RE: **Route 66 Plaza**
Grading and Drainage Plan
Engineers Stamp Date 6/16/16 (K19D043)

**RE: Route 66 Plaza
Grading and Drainage Plan
Engineer's Stamp Date 6-16-2016 (File:K19D043)**

From: Abiel X. Carrillo
Sent: Tuesday, July 12, 2016 4:01 PM
To: 'chagelgantz@abqeng.com'
Subject: K19D043 - Route 66 Plaza
Attachments: SO 19 NOTES with sig C.DOC

C-1

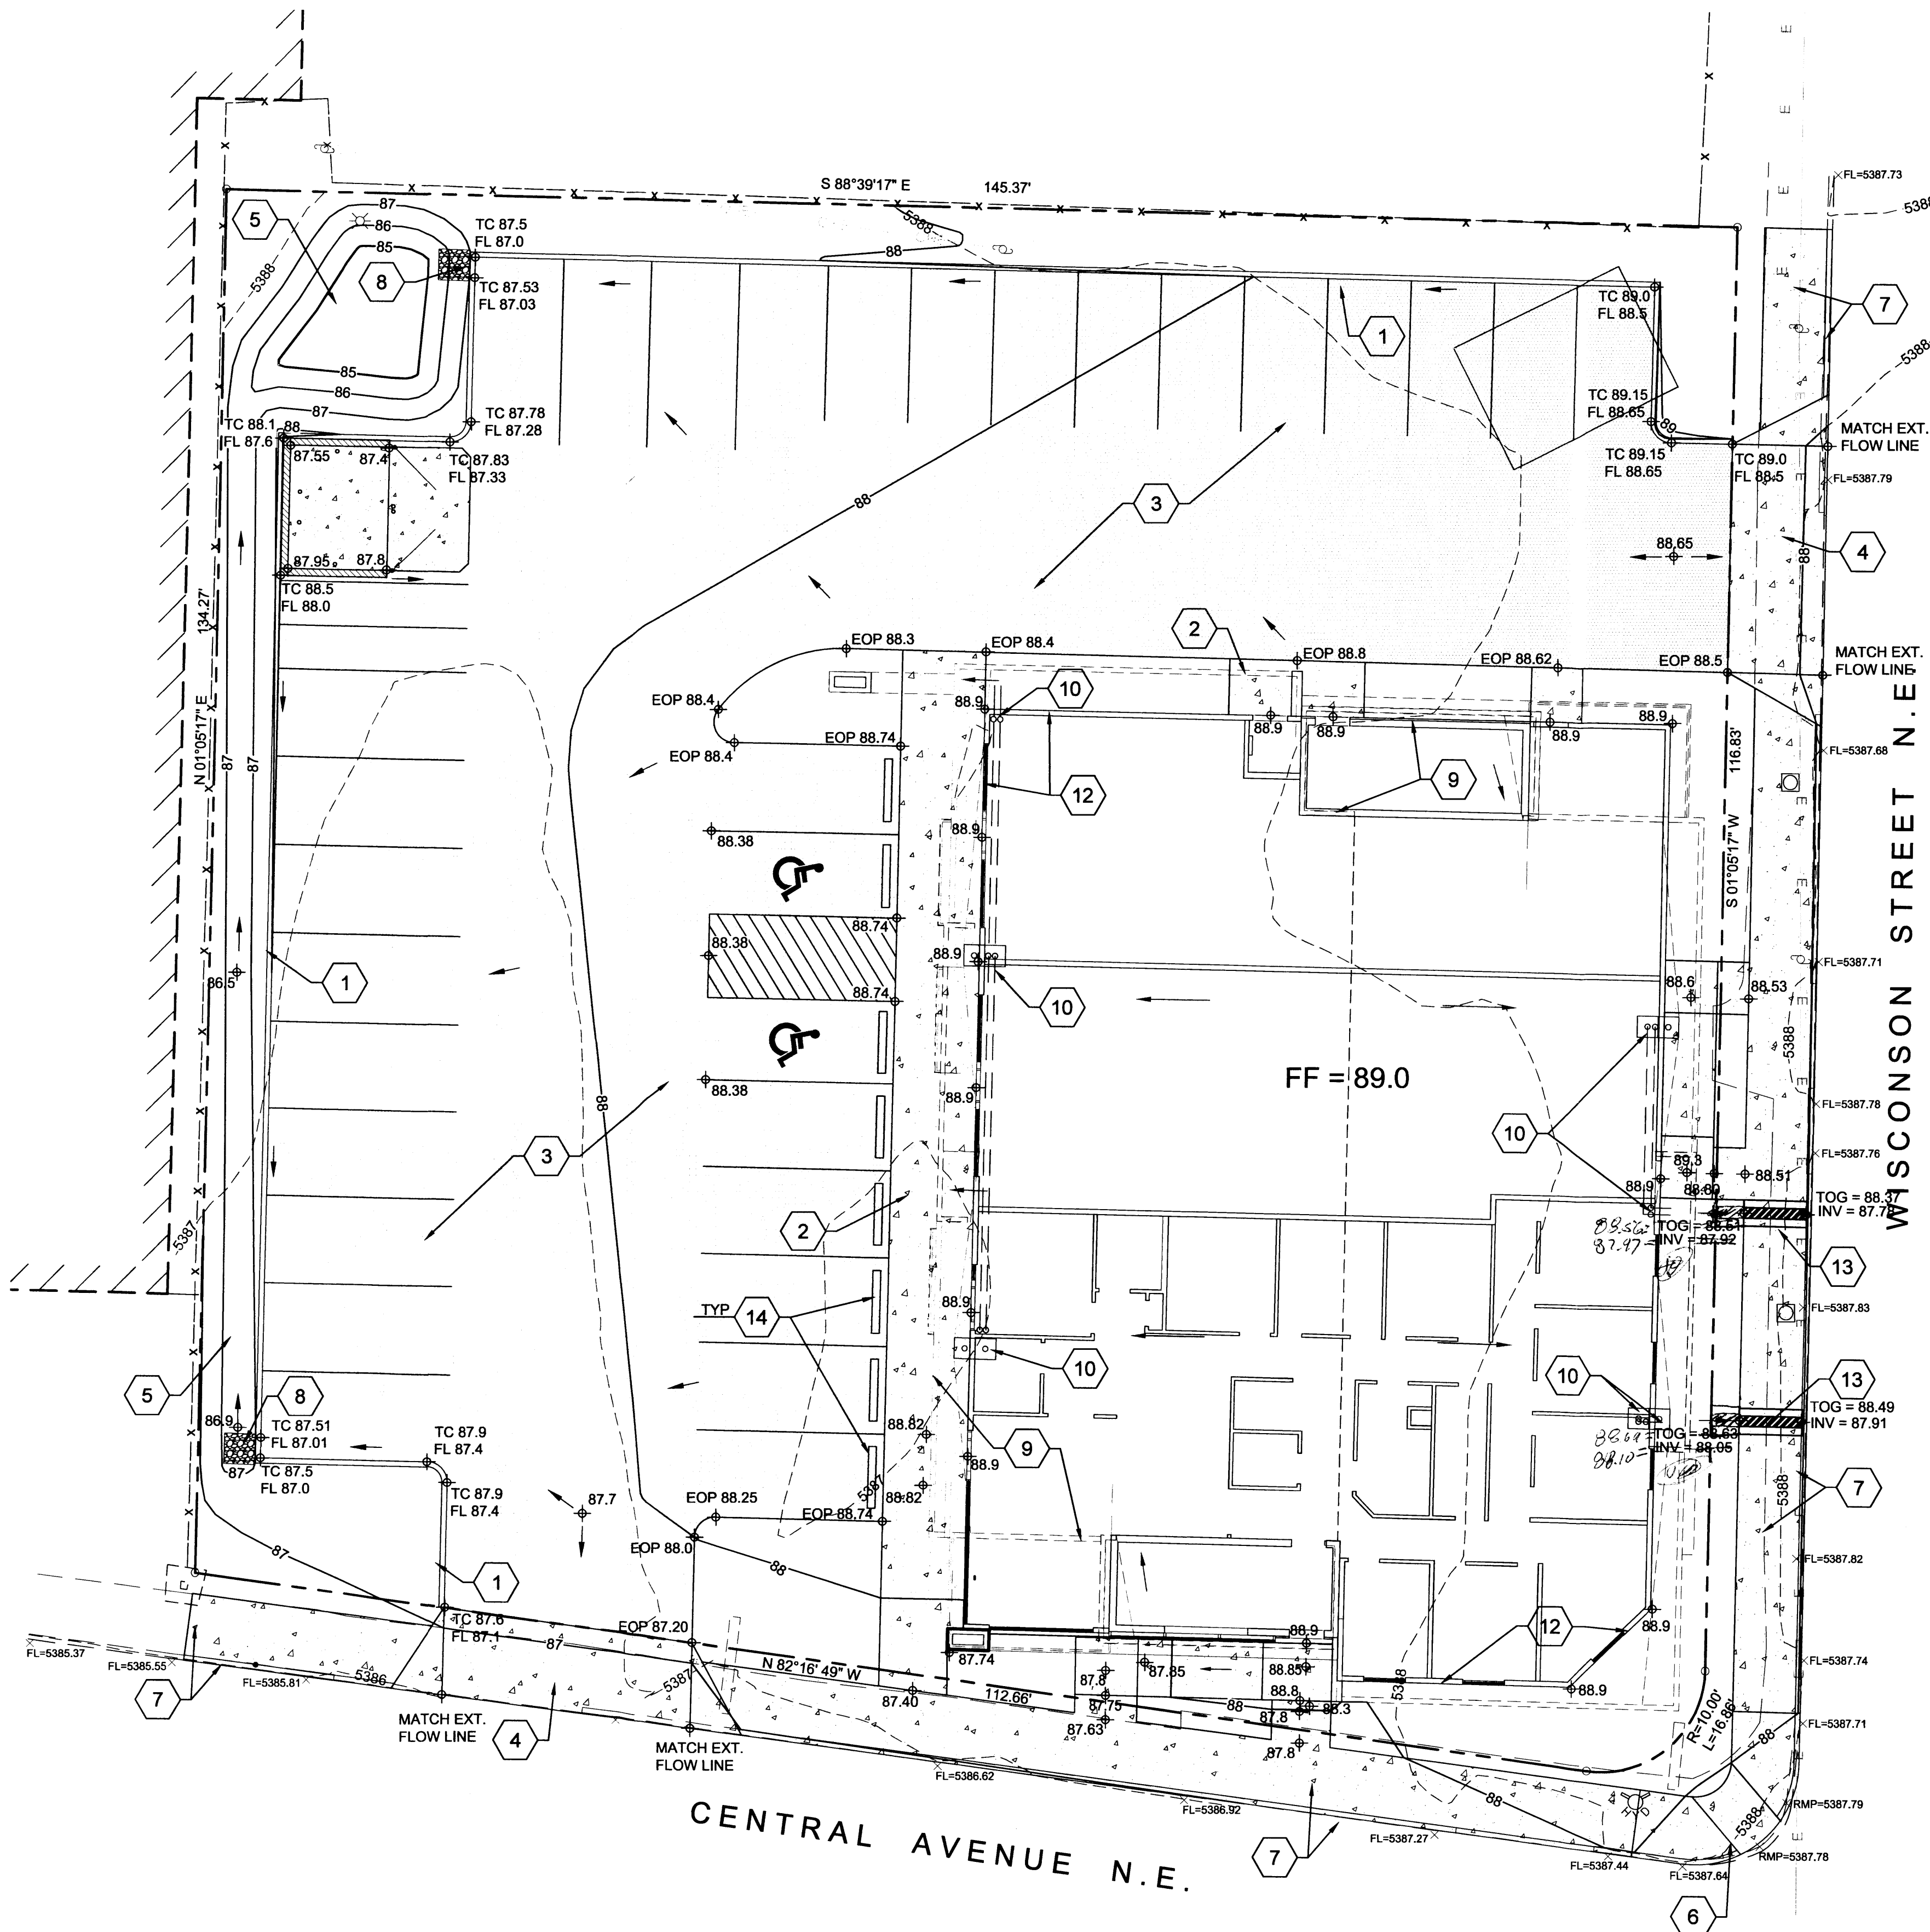
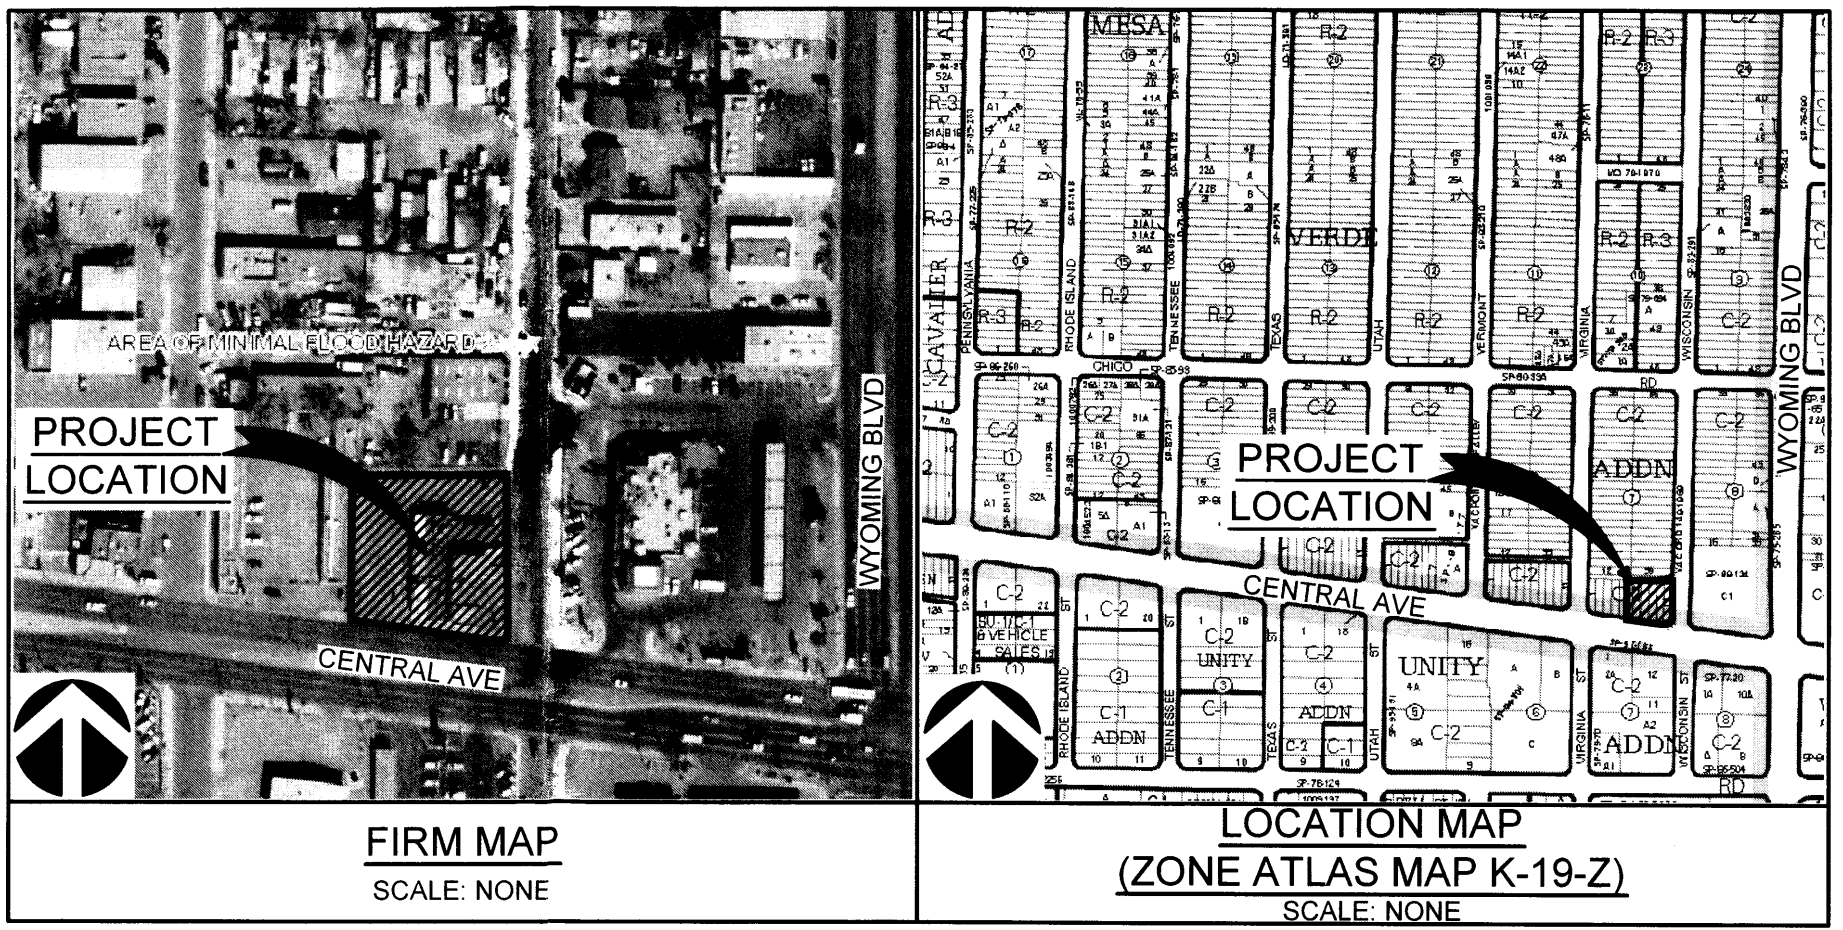
1. Generally, concentrated flows (above 0.2 cfs) cannot be discharged onto the sidewalk surface.
 - a. Roof drains along the west face of the building should be routed under the sidewalk with piping or a sidewalk culvert, or discharged to a landscaped area when possible.
 - b. Roof drains along the east face of the building need to flow under the sidewalk on Wisconsin Ave through a sidewalk culvert (flows can be consolidated with swales to reduce the number of culverts needed if feasible)
2. A sidewalk culvert on Wisconsin will require the plans to include the City's SO-19 Notes (for minor drainage structures within the right of way). Please include the attached notes on the plan.
